**Your ref: 2024/91747/E – Planning application, 1 Chadwick Crescent
WF13 2JF.**

Proposed Erection of single storey front, two storey side and single and two storey rear extensions.

**EXISTING SITE PLAN**

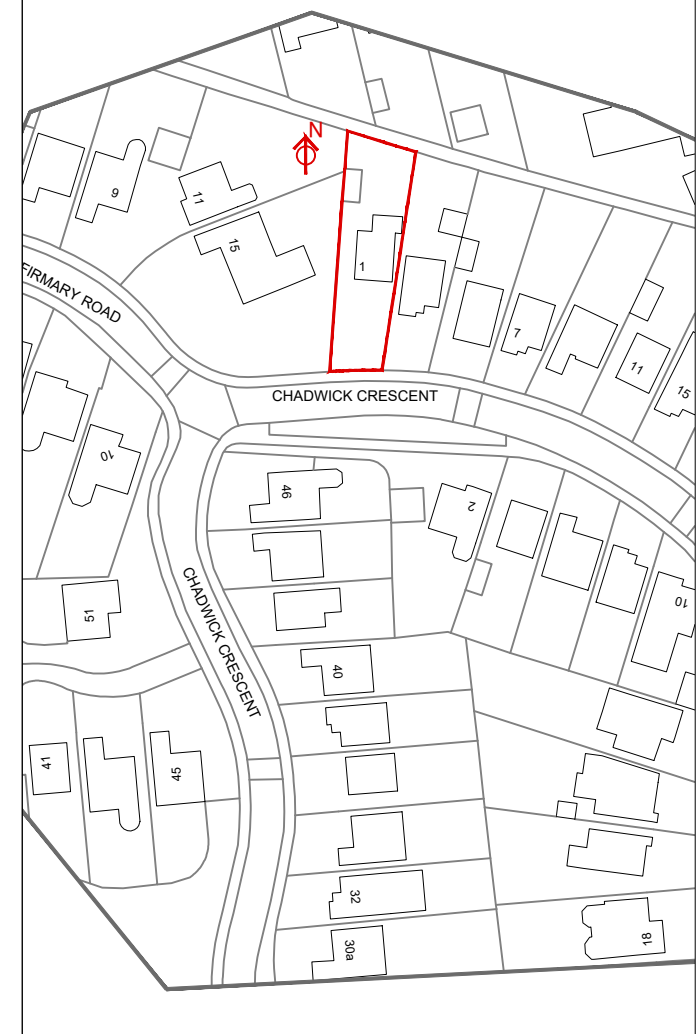
There are large trees in the garden of the proposed site. These have not been shown on the submitted drawings. Nonetheless several trees are subject of a TPO and therefore have a root protected area which usually spans the same distance as the canopy. Given the proximity of the trees to the development site it would create a somewhat inevitable and unacceptable pressure for pruning in the years ahead which would be detrimental to the sustained good health of the trees.
